From: Richard Temple
Sent: 09 September 2015 09:39
To: Planning.Responses
Subject: FW: Site 6 Felpham Y/58/15/DOC

WEST SUSSEX COUNTY COUNCIL
STRATEGIC PLANNING CONSULTATION

SUBJECT: Y/58/15/DOC - Application for approval of matters reserved by condition imposed under Y/68/09 relating to conditions 3 and 5- Stage One/Two Audit and Access.

TITLE:
SPORT PITCH ACCESS GHOST ISLAND OPTION

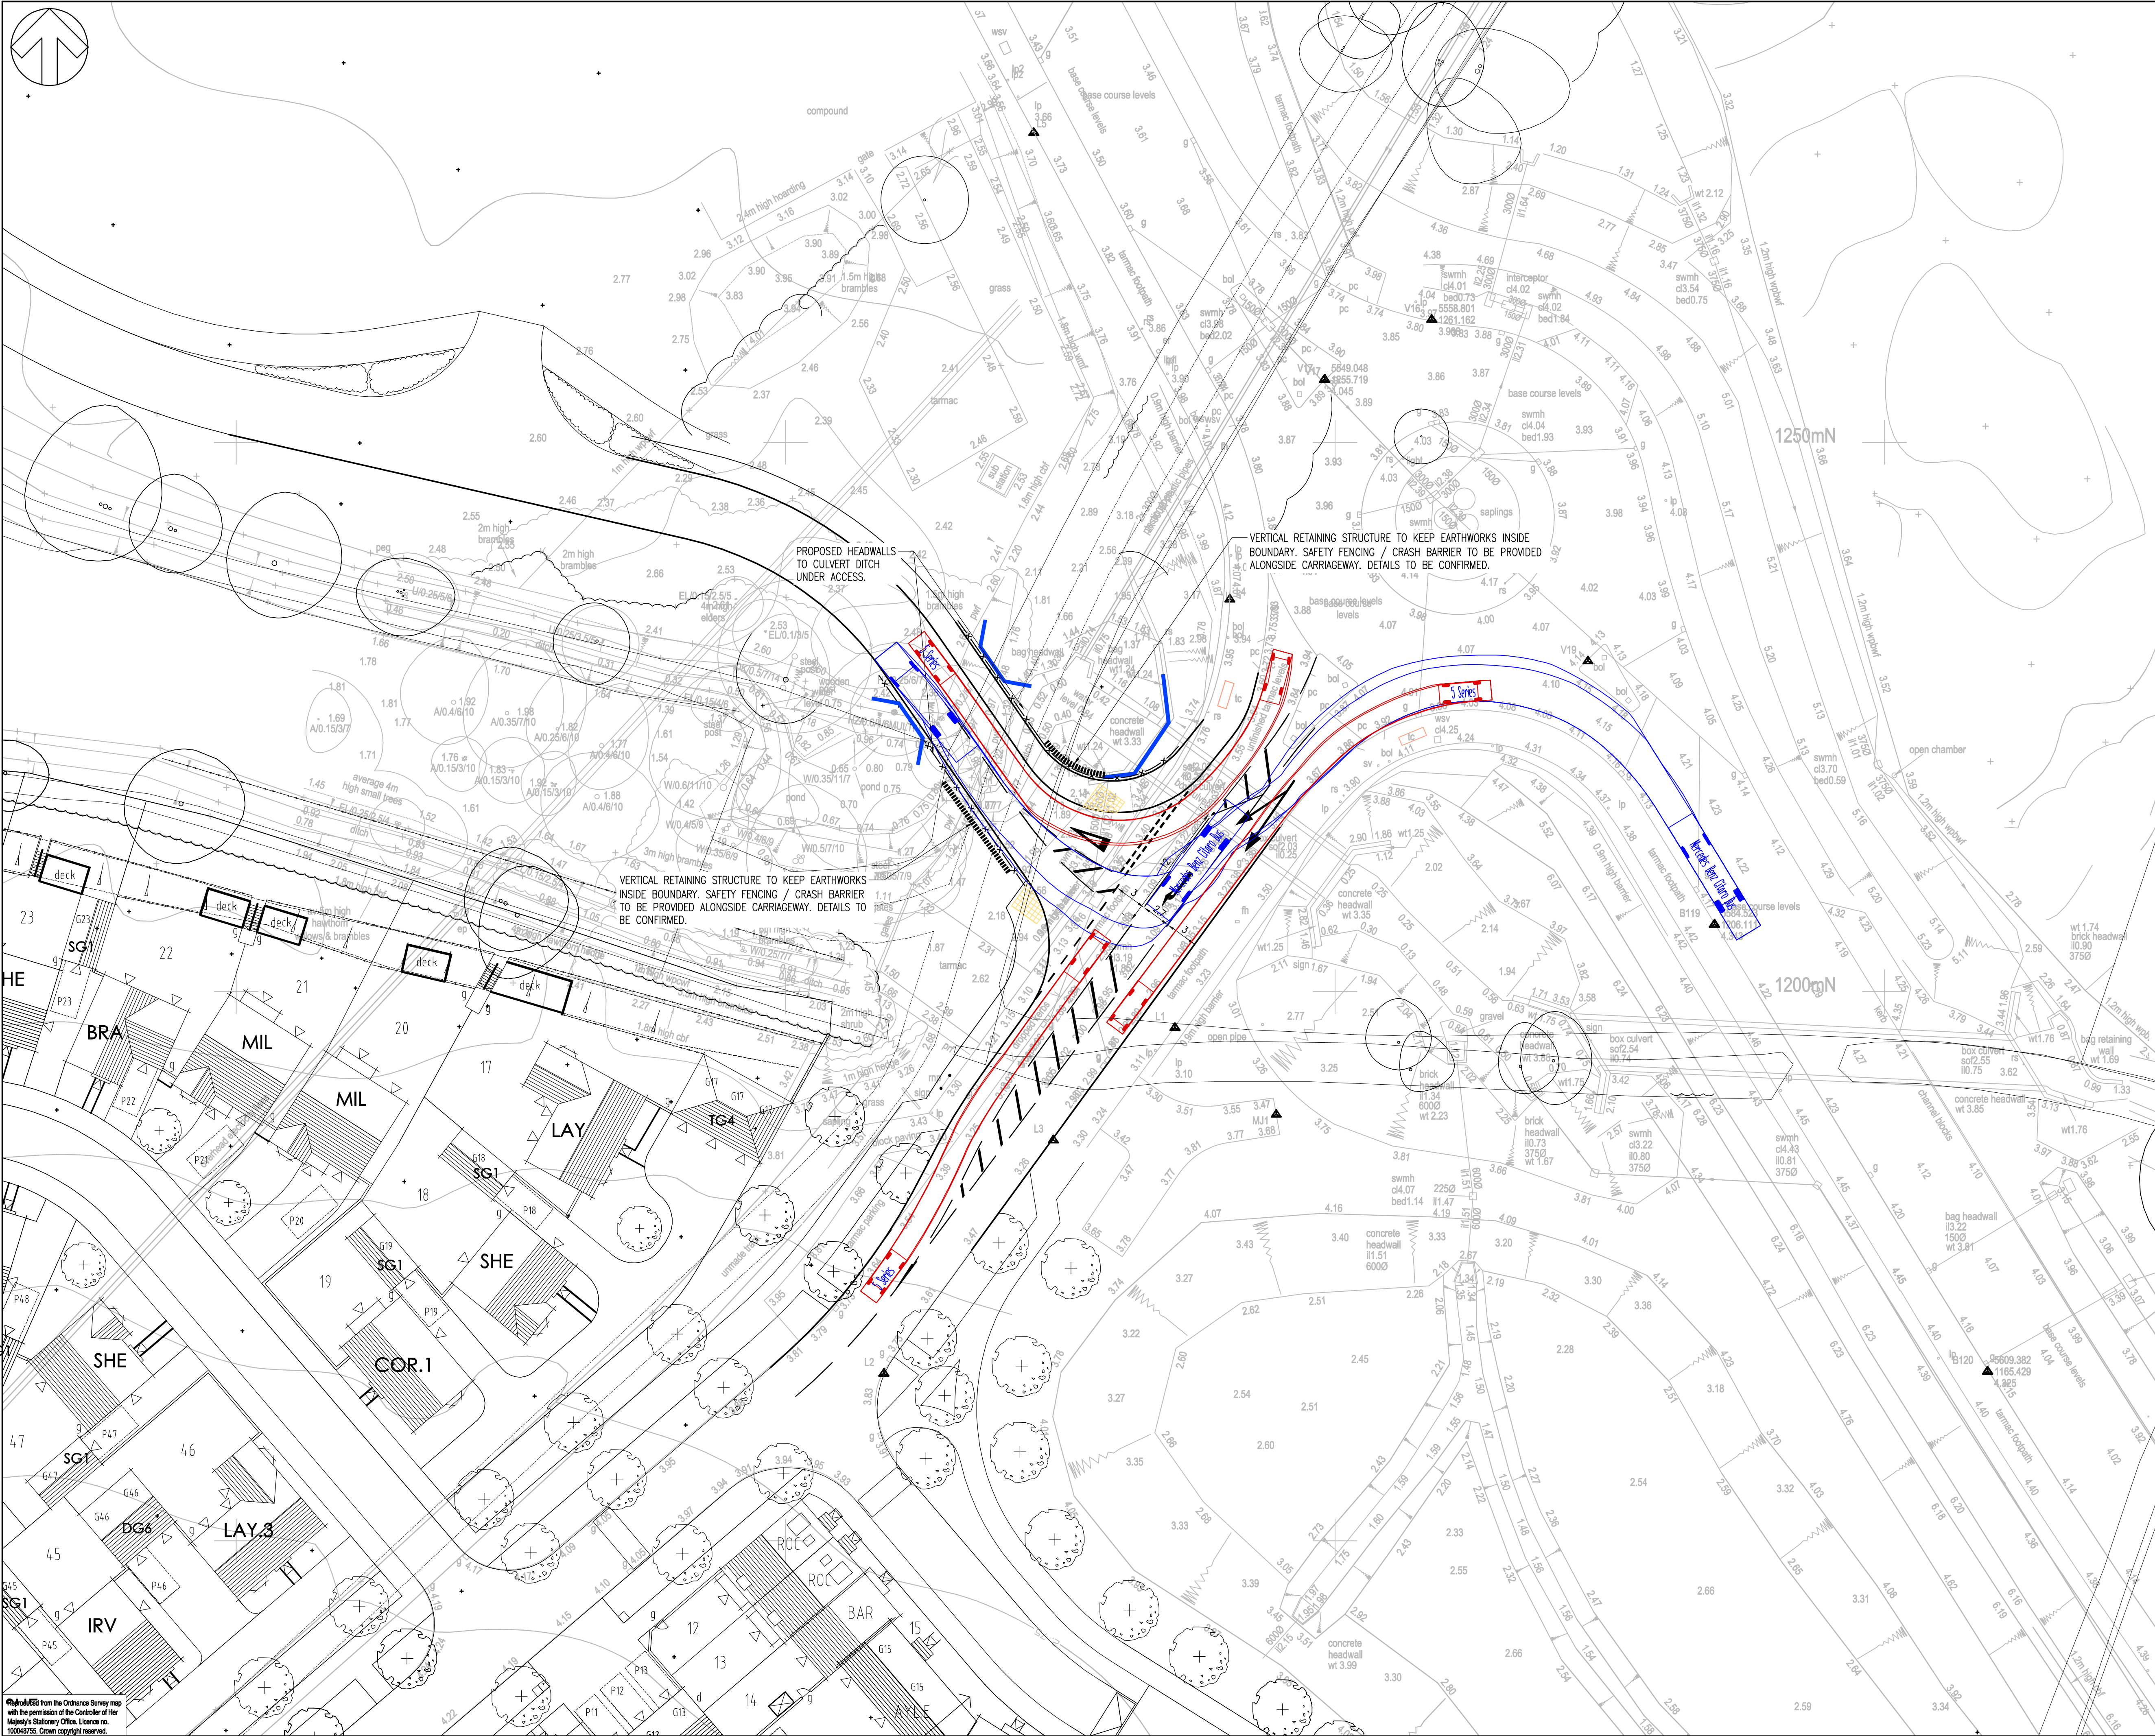
Condition 5 requires plans and details of the access to be submitted, and for the access thereafter to be constructed in accordance with the approved details. As part of Y/68/09 the access was shown as a simple priority junction. Various concerns were raised by the LHA regarding this arrangement. It was however accepted that the arrangement had been approved by way of the 2004 outline permission covering the wider residential site. Even so, the junction arrangement has now subsequently been altered primarily to suit the problems identified within the Stage One/Two RSA.

In principle, the arrangement now shown offers a potential betterment to that approved. The applicant would still need to demonstrate what standards have been applied to the revised design and how the design complies with these. In these respects a design audit or commentary of what standards have been applied would be appropriate. Advice on what should be included within this is detailed in the note appended to this response. If the scheme cannot comply with the relevant standards, departures may need to be sought. The LHA can advise the applicant accordingly on this process.

- Extend the right turning lane length northwards as much as possible towards the Relief Road Roundabout.
- The hatching within the access should be removed as this will potential encourage pedestrians to cross in two phases.
- The use of a bus as the design vehicle for the access is noted. In light of the facilities proposed, realistically will a vehicle of this nature be a frequent visitor to the site?
